**WELWYN HATFIELD COUNCIL – DEVELOPMENT CONTROL**  
**DELEGATED REPORT**

<b>APPLICATION No:</b>	<b>S6/2009/1553/FP</b>
------------------------	------------------------

The proposal seeks full planning permission for a single storey rear extension following demolition of the existing conservatory and attached garage to the new extension. The extension would project 6 metres beyond the existing dwelling and the garage adjacent to no. 17 would extend a further 2.5 metres beyond this (i.e total depth of 8.5 metres).

DWG No: CRUM/3

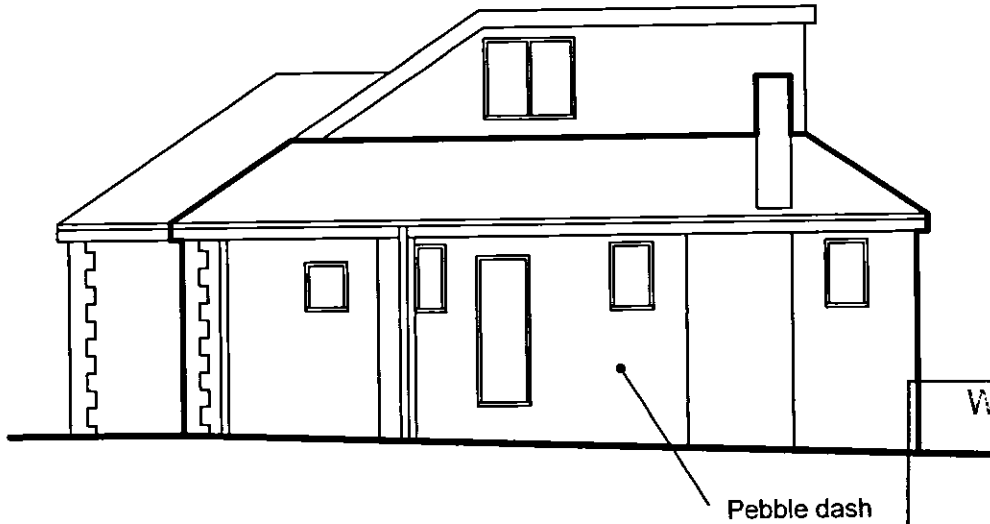
The submitted existing plans are inaccurate in that the existing conservatory and garage are not shown on either the floor plans or elevations.

1. Drawing numbers CRUM/1, CRUM/3, CRUM/4, CRUM/7 are all inaccurate in that they do not show the existing conservatory or garage; CRUM/5 should be annotated 'proposed' front elevation not existing as shown
2. This planning permission does not grant permission for any raised platform or terraced area which has a height greater than 300 millimetres. Planning permission would be required by submission of a further planning application for such development (refer The Town and Country Planning (General Permitted Development) (Amendment) (No. 2) (England) Order 2008.

SCALE	1:100
DATE	June 09
DRAWN BY	AC
CHECKED BY	
DWG No:	CRUM/9

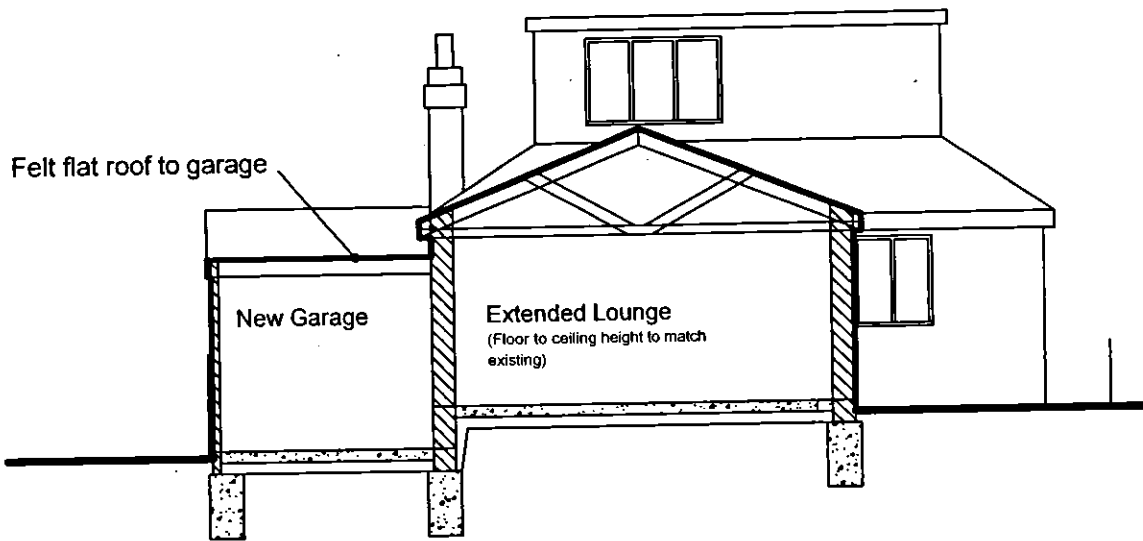
3. The proposal is providing garaging with an internal clearance of approximately 2.8 metres. It is therefore considered possible that this building could be used for parking. No additional bedrooms are proposed with this development. It is therefore considered that the level of parking provision is acceptable.
